Subject: Exhibition of 7 Railway Street, Chatswood (MP09_0154)

SCHEDULE 1 – KEY ISSUES

SCHEDULE 2 – ADDITIONAL INFORMATION REQUIRED / COMMENTS

SHADOW DIAGRAM - JUNE 21ST 3PM

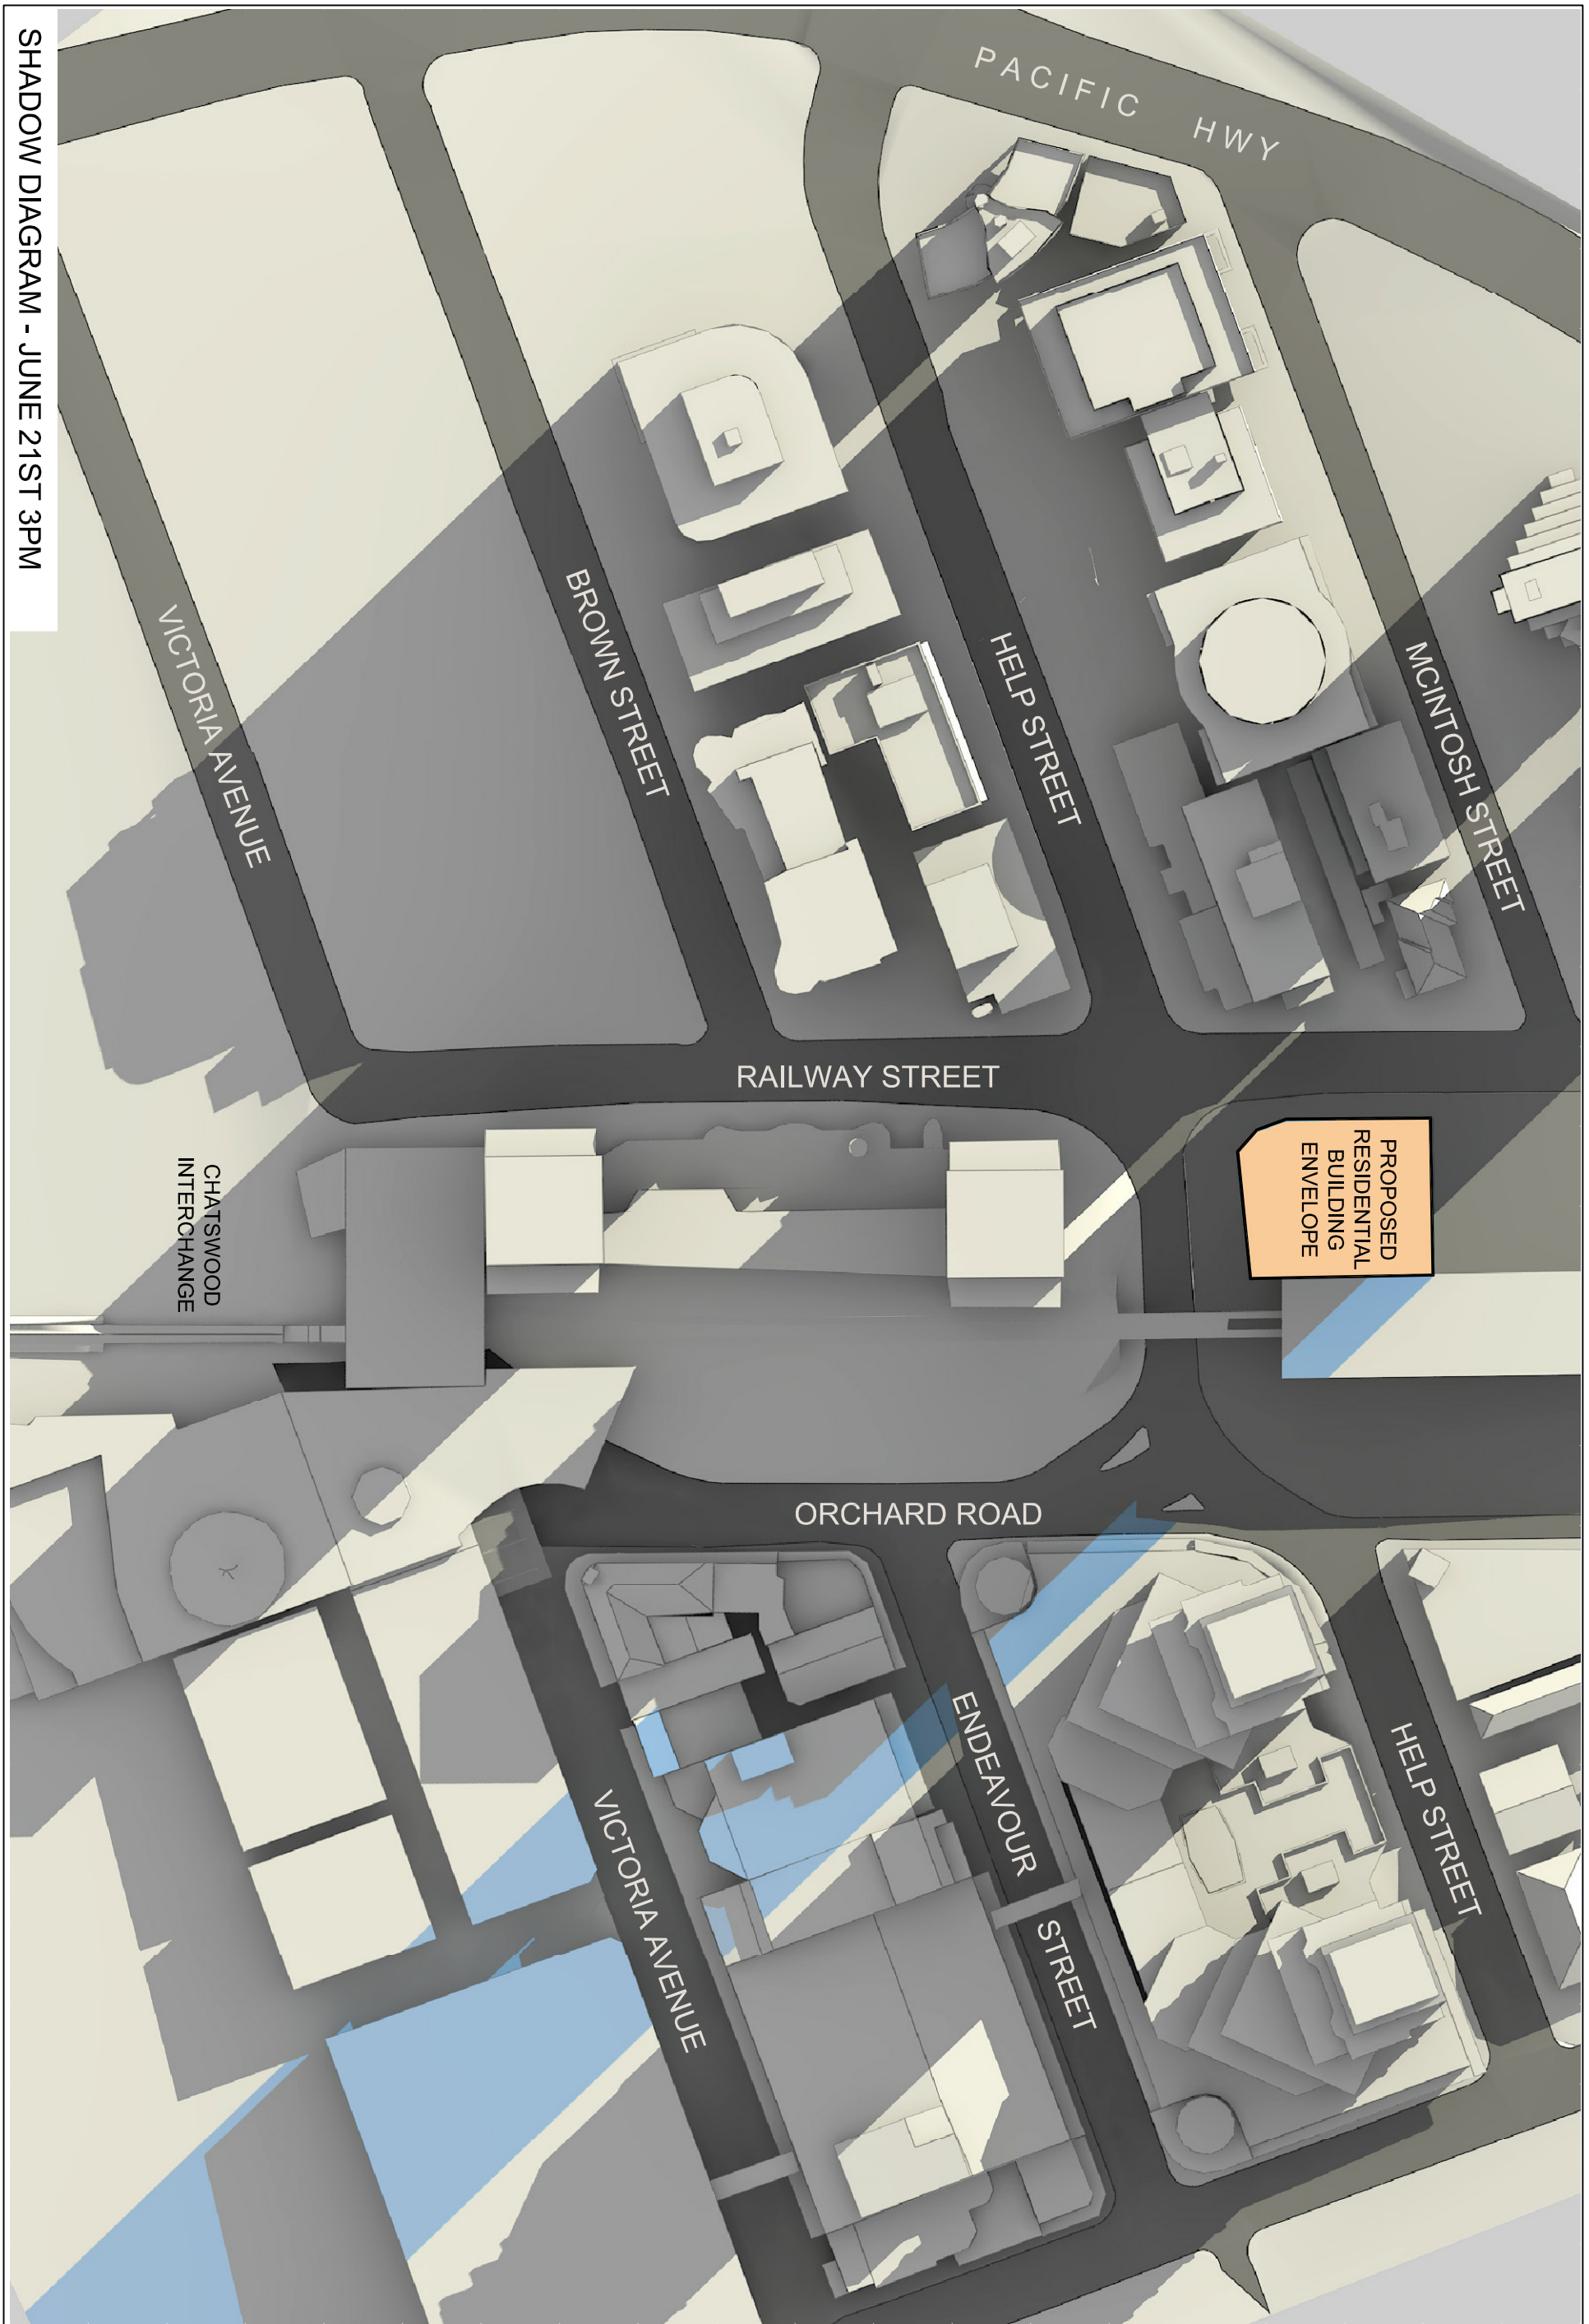
- A shadowing analysis detailing the shadow cast on the proposed building by neighbouring towers at 9am, 12noon and 3pm at 21 June should be provided to demonstrate that at least 70% of living rooms and balconies can achieve 2 hours solar access in accordance with the SEPP 65 Residential Flat Design Code.
- A response and/or additional plans to address Council's concern that the proposal will increase overshadowing of Chatswood Mall. The response should address the concern that the proposal *"lengthens the shadow cast considerably and, therefore, increases the height of the impact and the awareness of shadowing"*.
